Town & Country Planning Act 1990 (as amended)
Town and Country Planning (Development Management
Procedure) (England) Order 2010 (as amended)
Application for Planning Permission
DECISION NOTICE

Application Ref: WA/42/13/

Slate Barn Farm
 Binsted Lane

Conversion of redundant farm building into family guest accommodation.

PROPOSED FLOOR PLAN

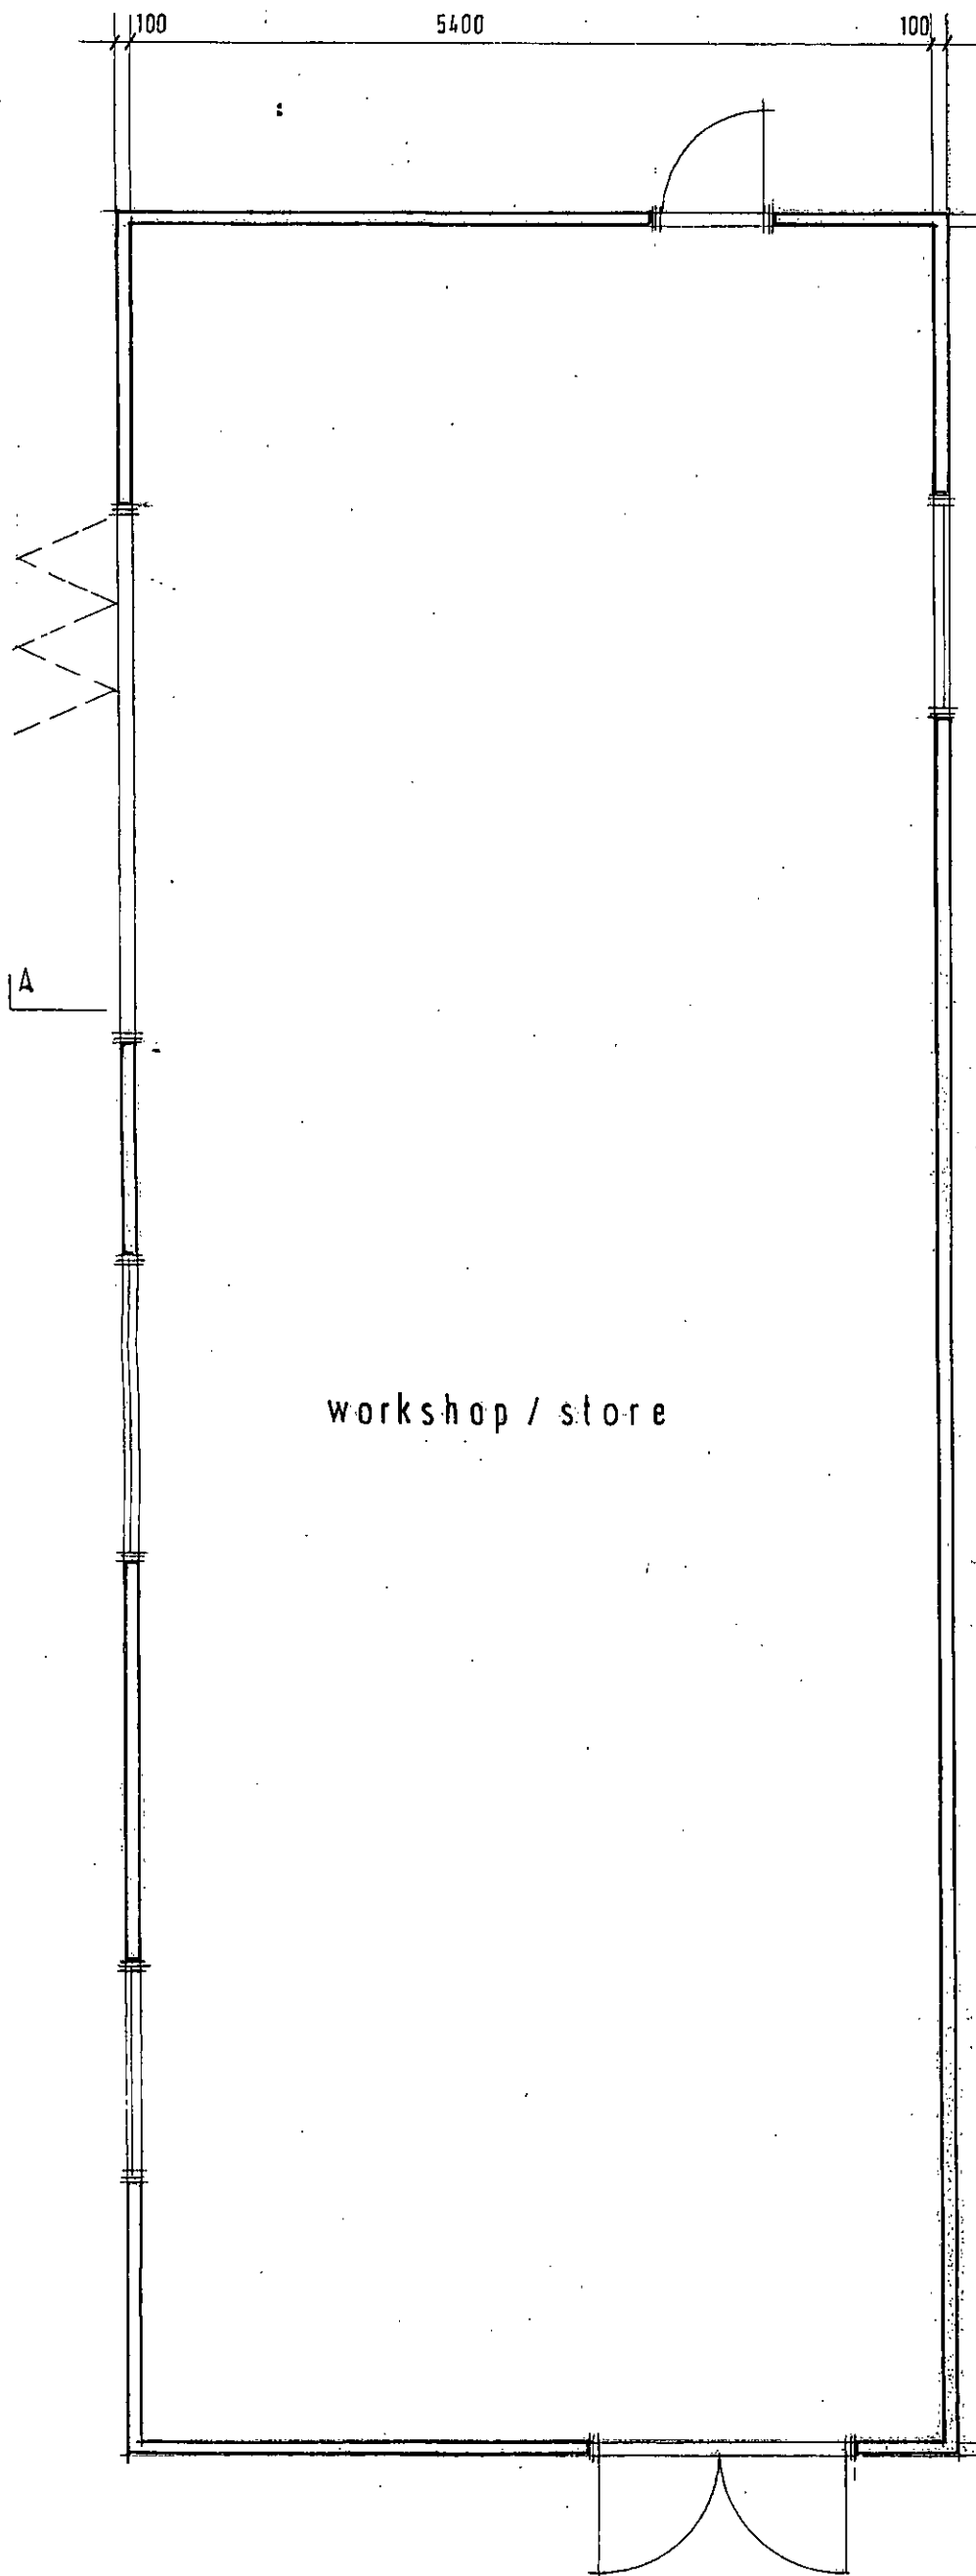
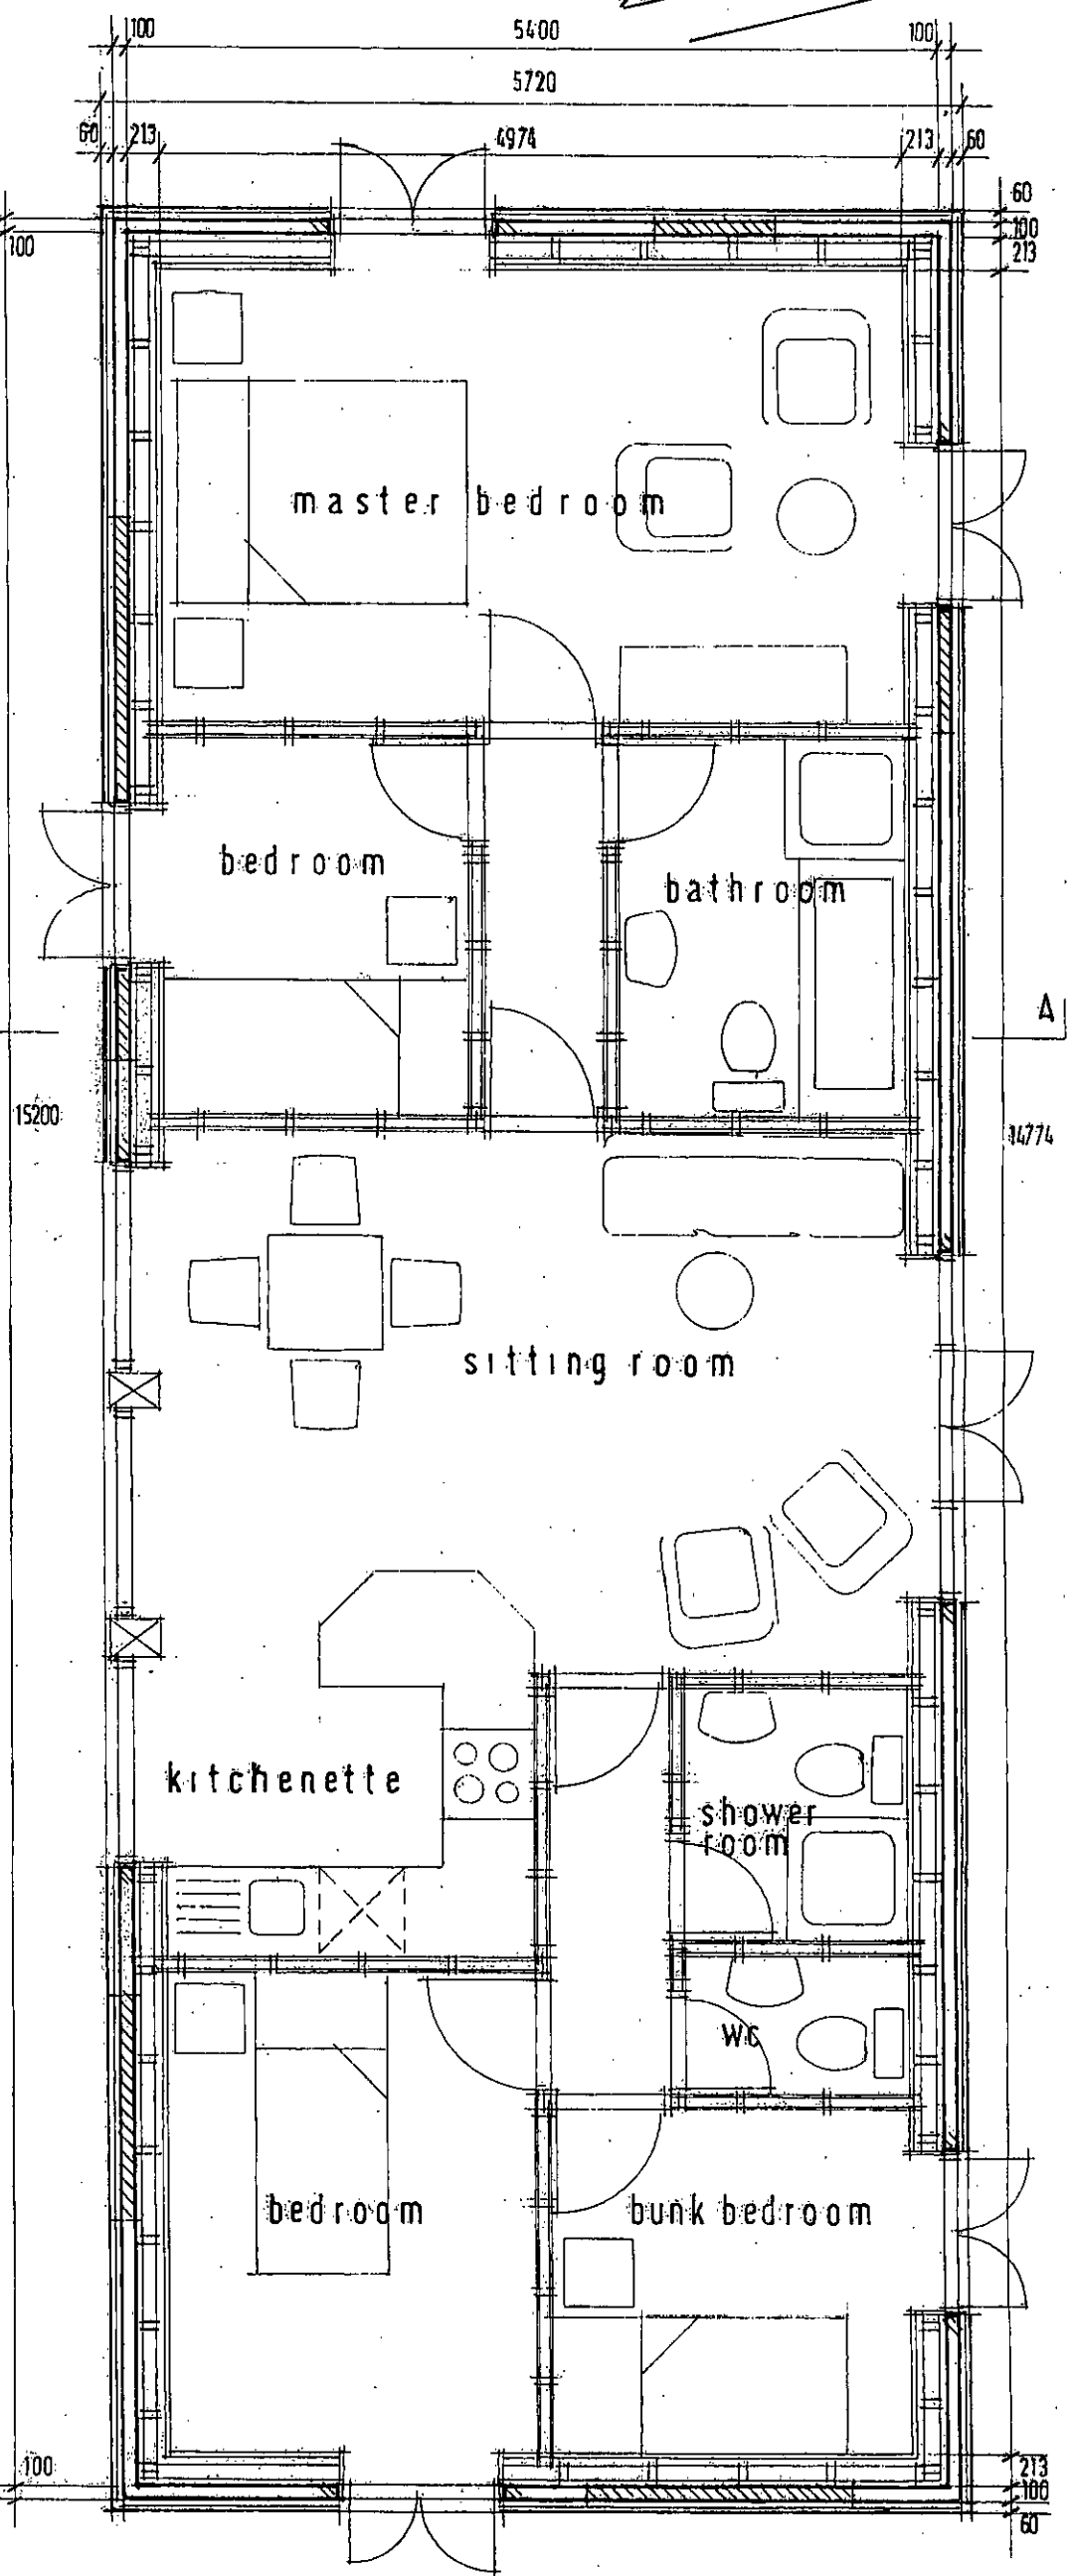
- 2 Given the extent and nature of the accommodation proposed the Local Planning Authority is not satisfied that the unit would be ancillary to the use of the farm house as a single residential dwelling. The proposal is therefore unacceptable to the Local Planning Authority which seeks to control very strictly all residential development outside the built-up areas and, in particular, requires that permission will not normally be granted for the extension of isolated groups of houses or the consolidation of linear or sporadic development, and therefore conflicts with policies GEN2, GEN3, GEN7 of the Arun District Local Plan for the countryside.

proposed SECTION A - A

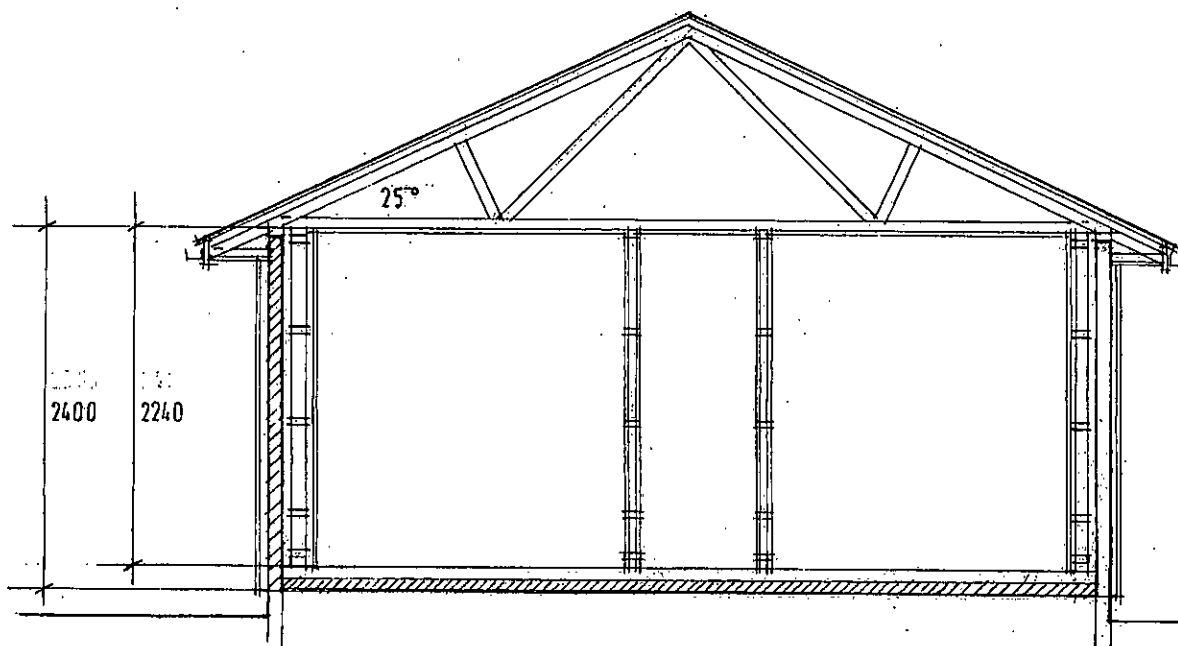
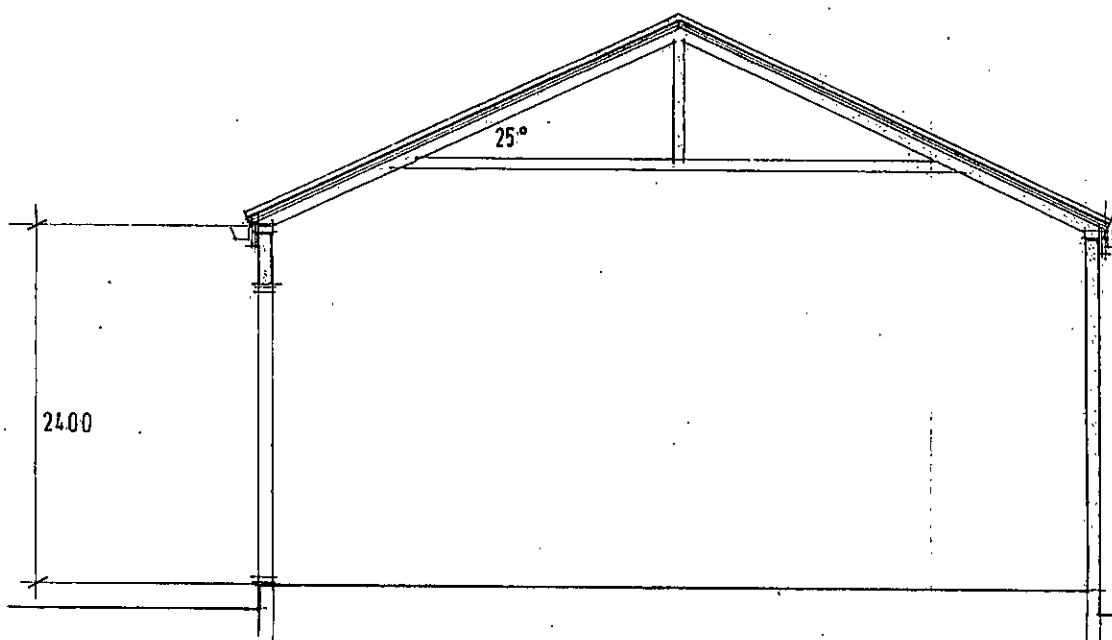
- 1 The proposed conversion is unacceptable in that it has not been satisfactorily demonstrated that the building is of sound construction and capable of conversion without significant rebuilding or alteration. It is also considered that the rural character and appearance of the building and locality would be adversely harmed by the number and size of the new openings. The proposal is therefore considered to conflict with policies GEN3, GEN7 and DEV2 of the Arun District Local Plan.
